August 30, 2016

## **Addition to Bayside Bowl Portland, Maine**

### **Plan Revision Narrative**

# A1-1

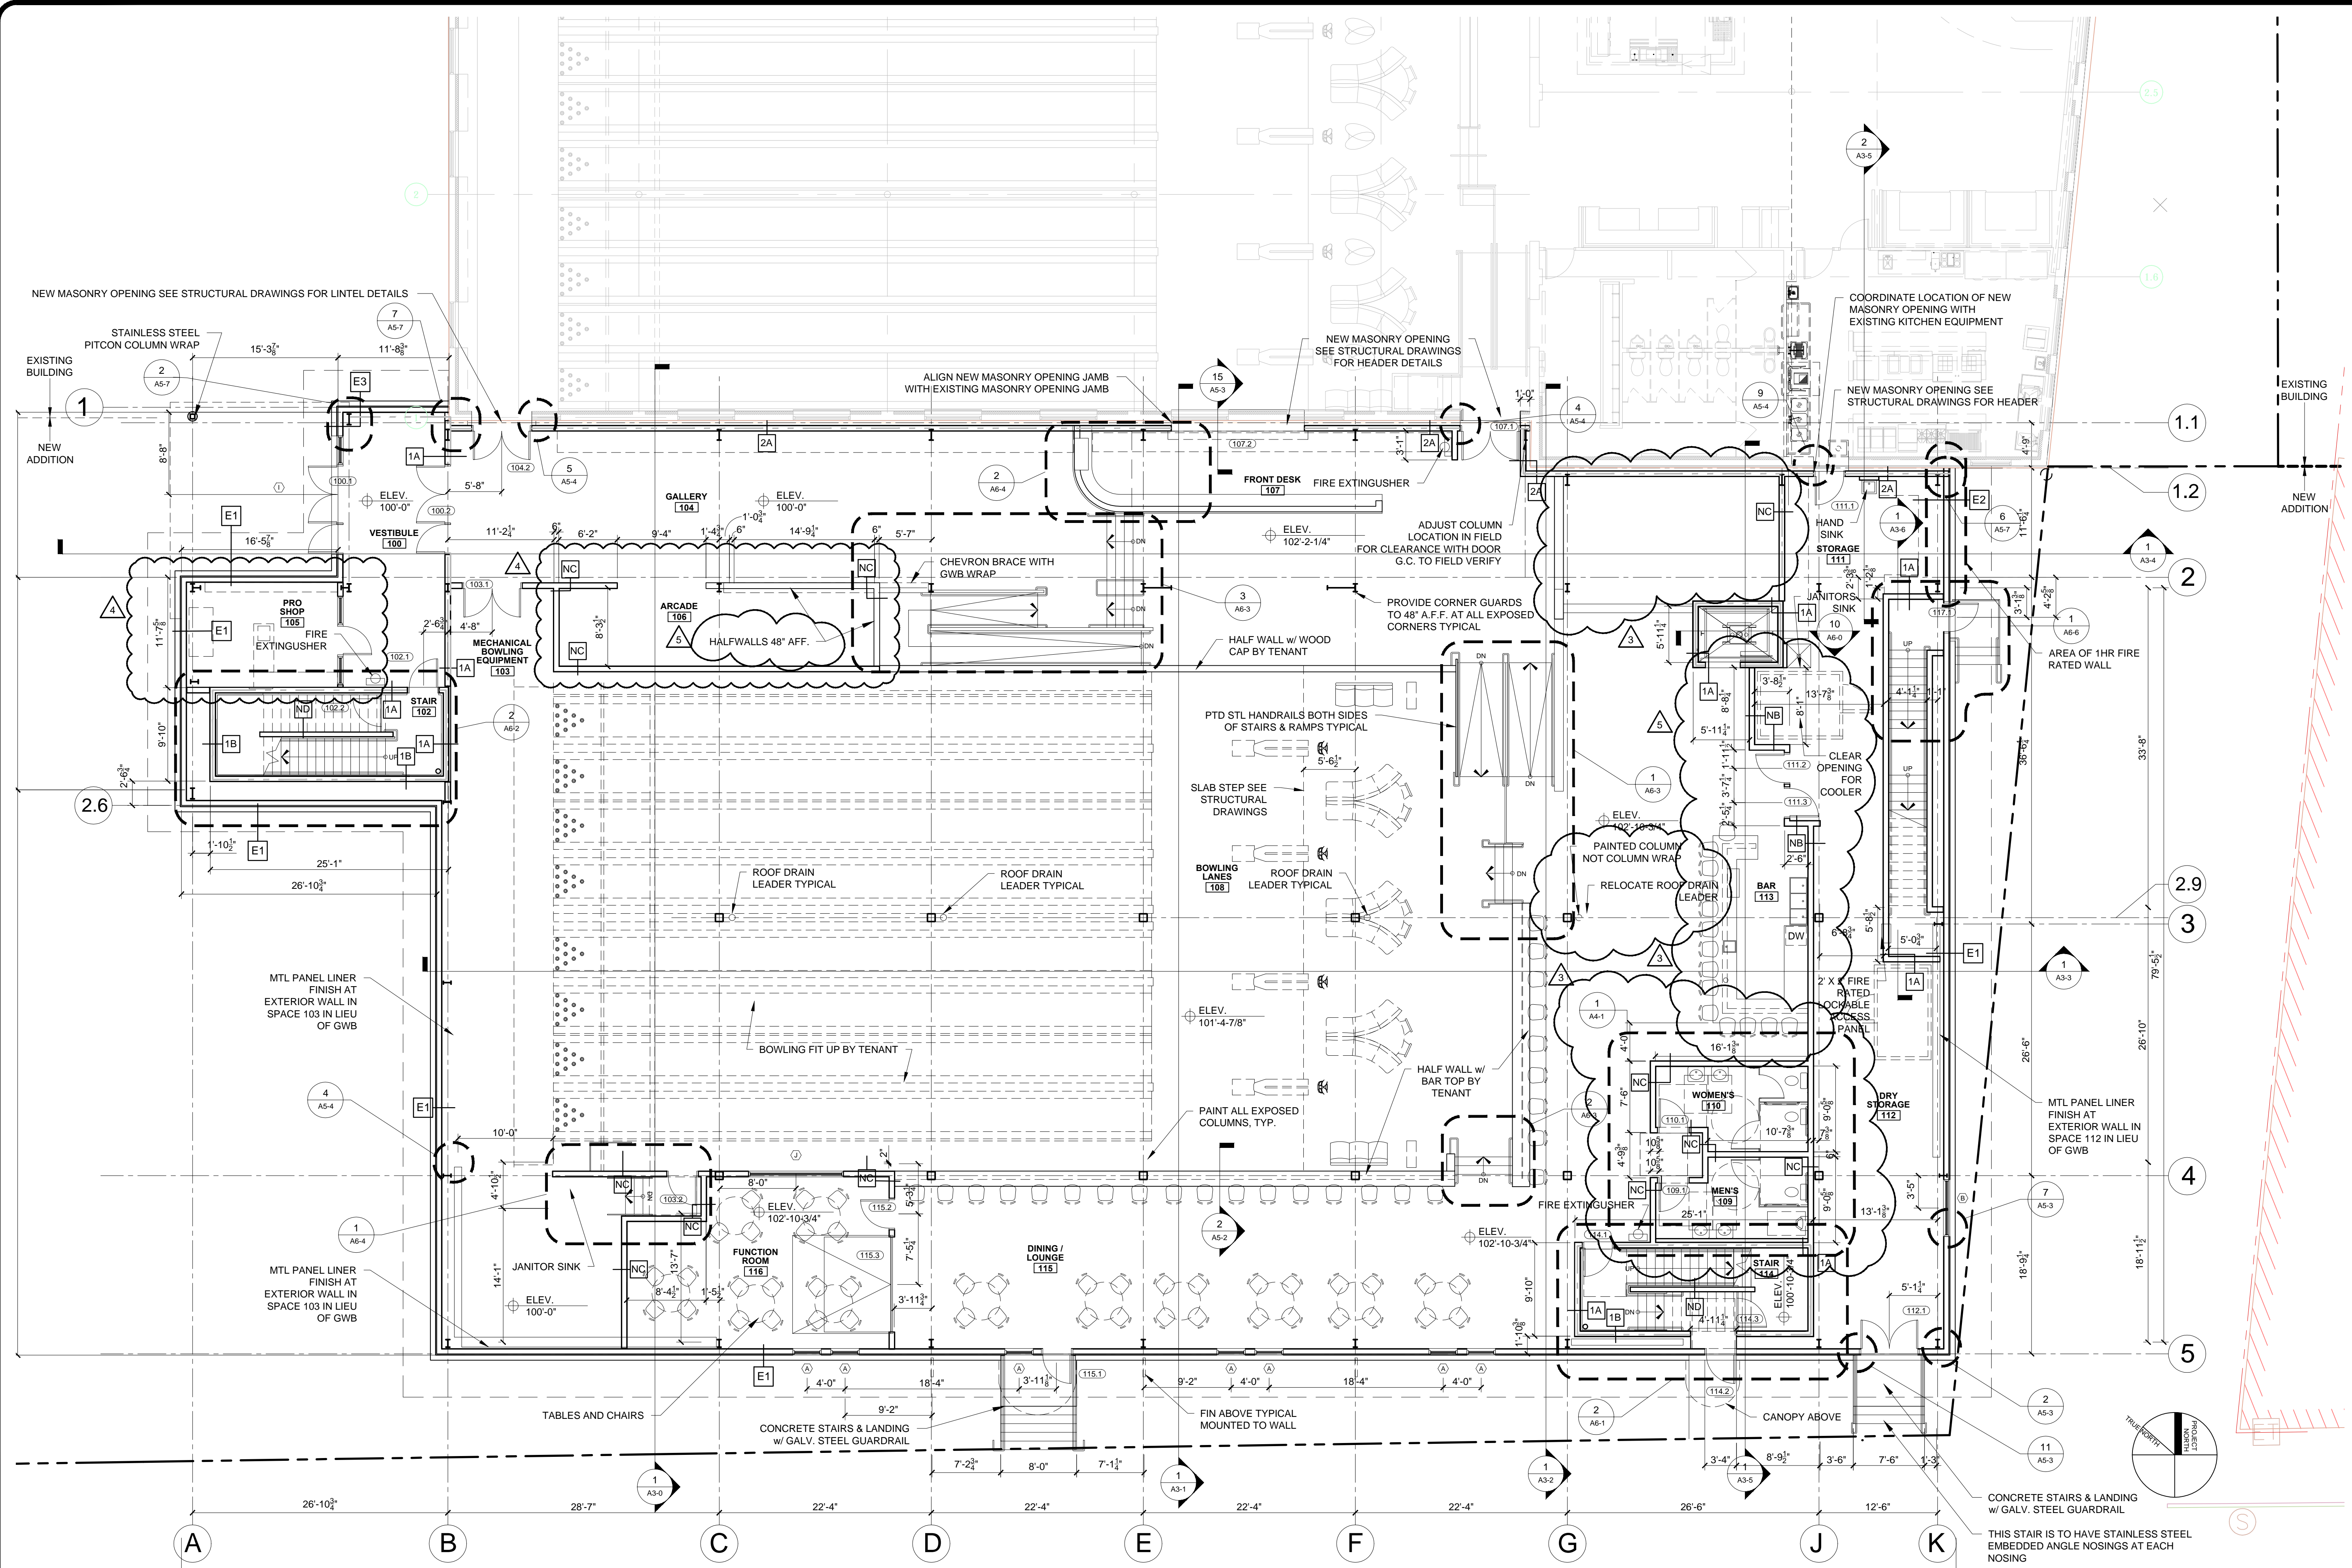
- 1.) Drawing A1-1 and ASK-03, we relocated the Pro Shop and reconfigured the coatroom into an area for a small arcade
- 2.) Drawing A1-1 and ASK-06, we relocated the first floor bathrooms toward Stair 114 and raised a section of the floor at the previous bathroom location to provide a raised seating area.

- 3.) Drawing A1-1, we modified the shape of Bar 113 slightly to accommodate the new bathroom location
- 4.) Drawings A2-1, A2-2, A2-3, and ASK-05, we revised the roof top deck size and shape by extending the exterior canopy that is attached to the egress Stair by 21' in length. The larger deck increased the occupant load at the roof level by 24, for a total of 160 occupants.

ASK-2

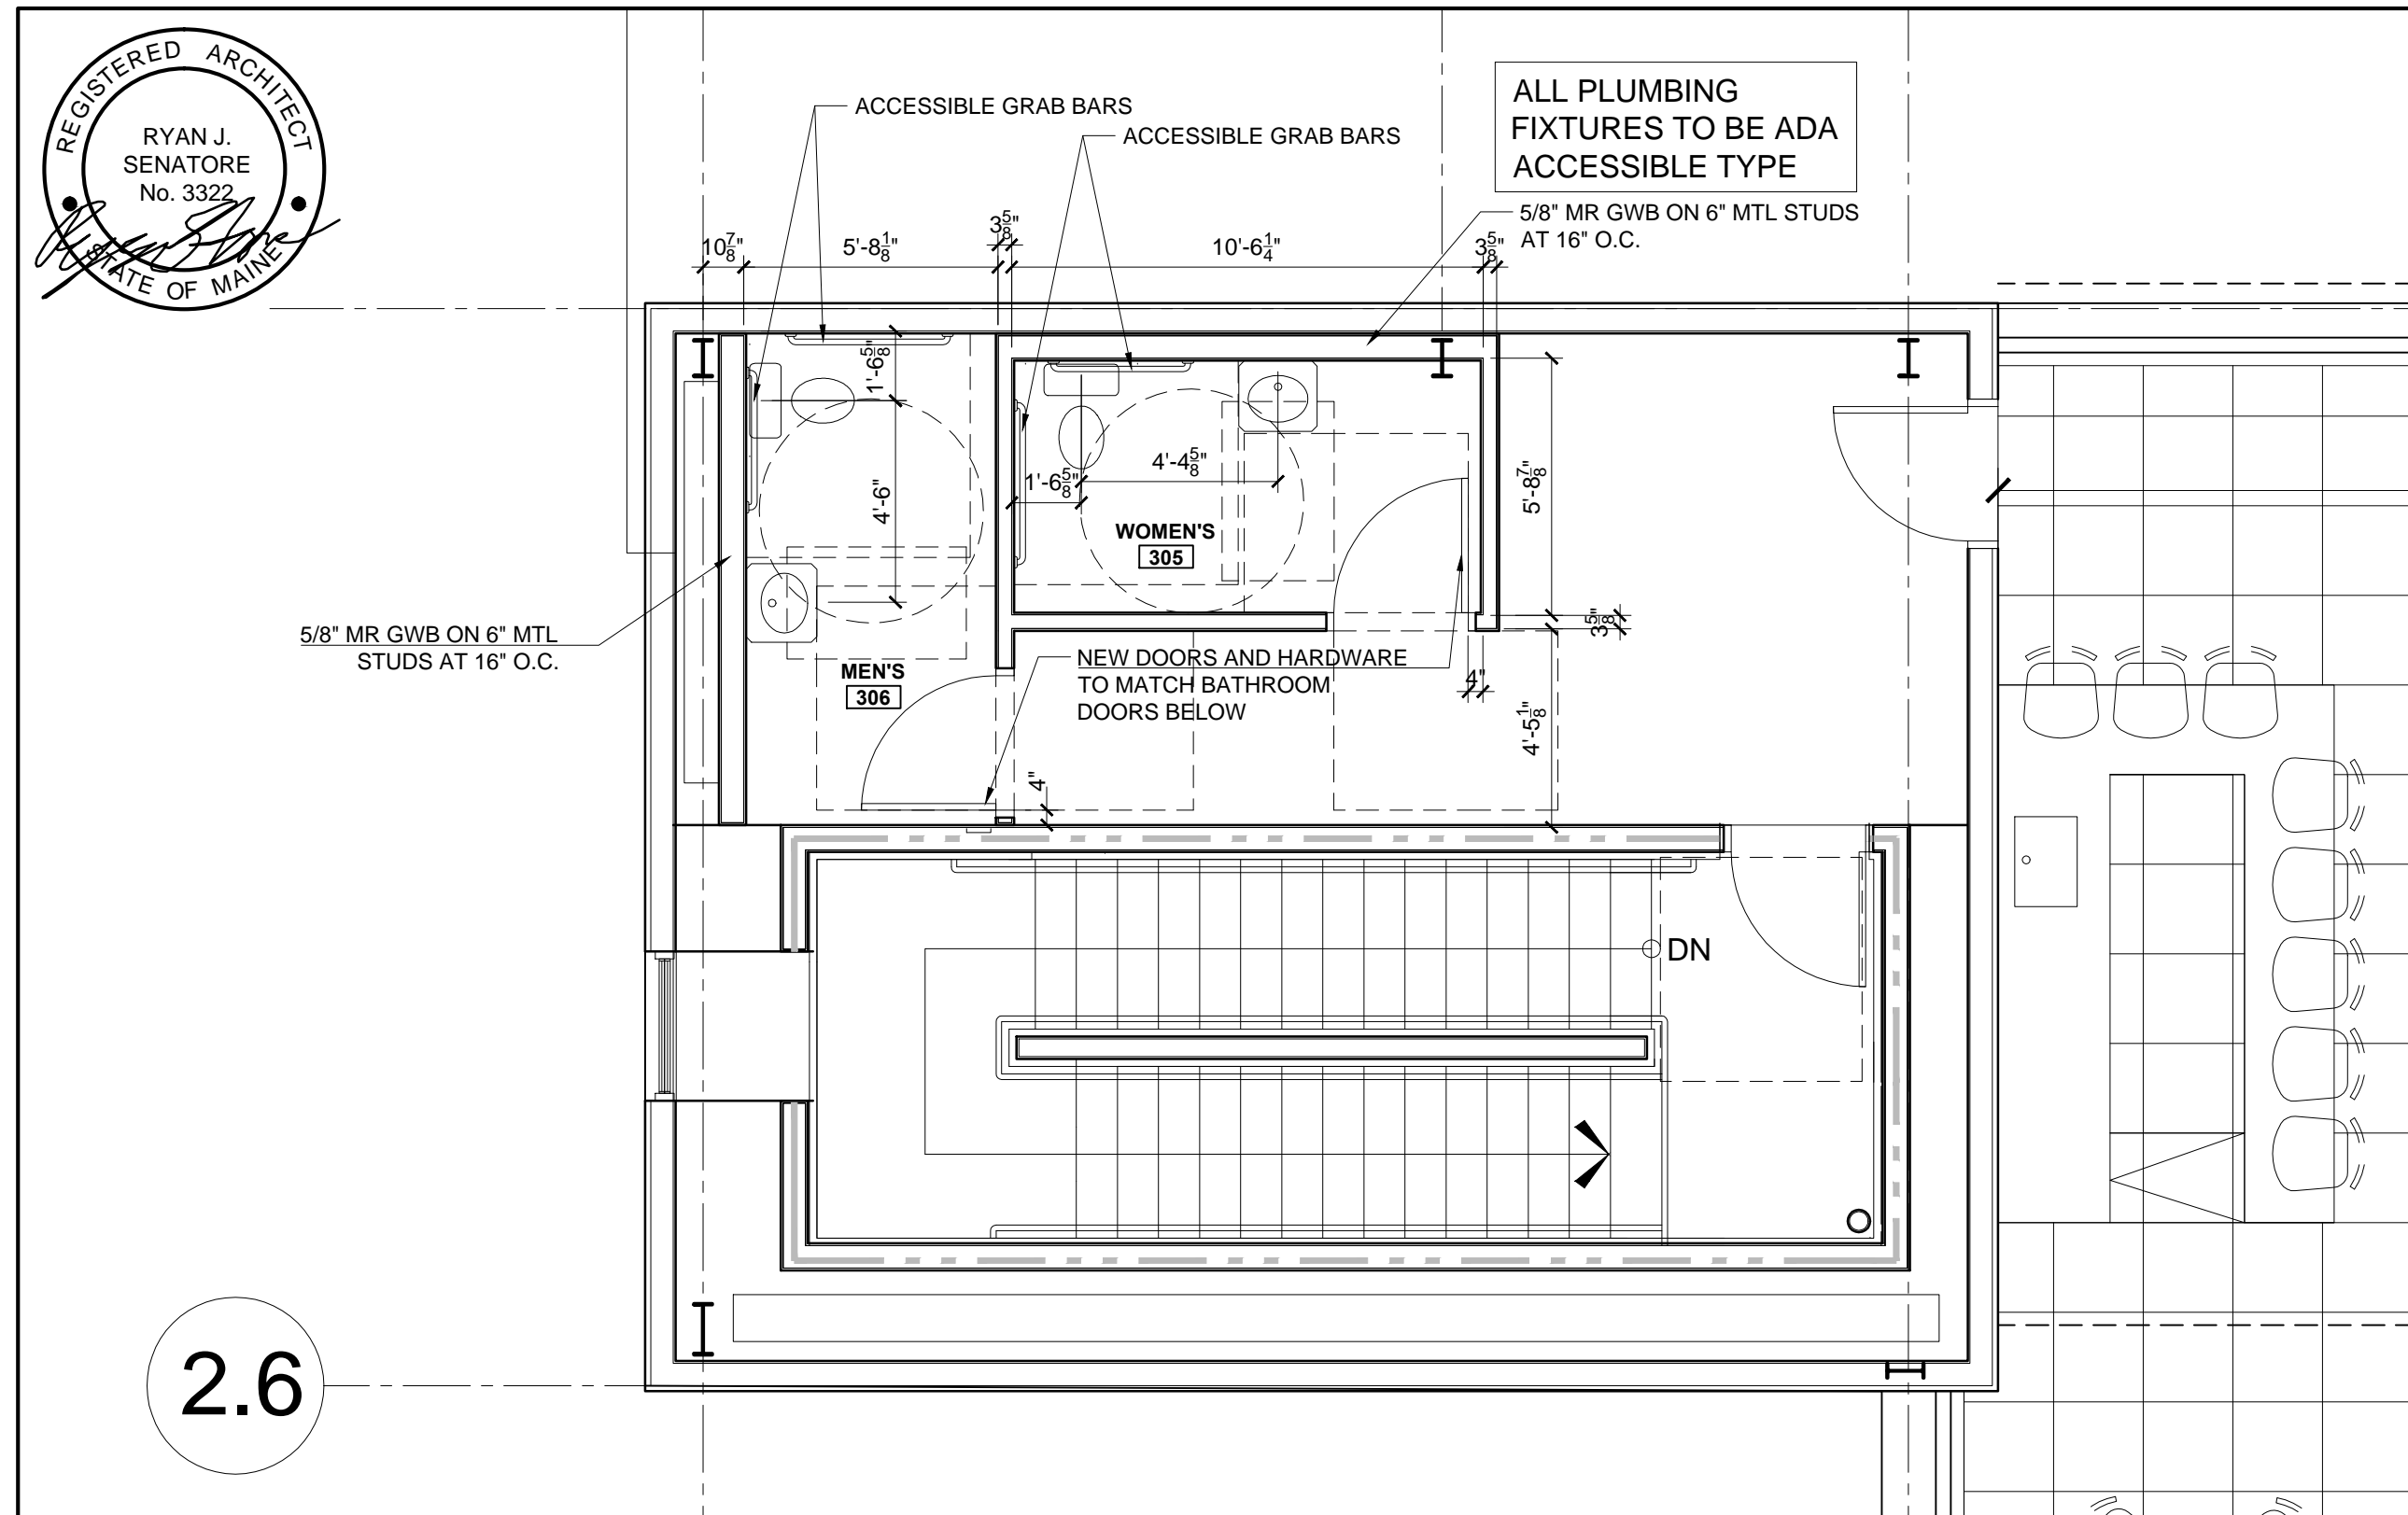
- 6.) Drawing ASK-05 and ASK-02, We have added two Accessible restrooms at the roof top level adjacent to the egress stair.
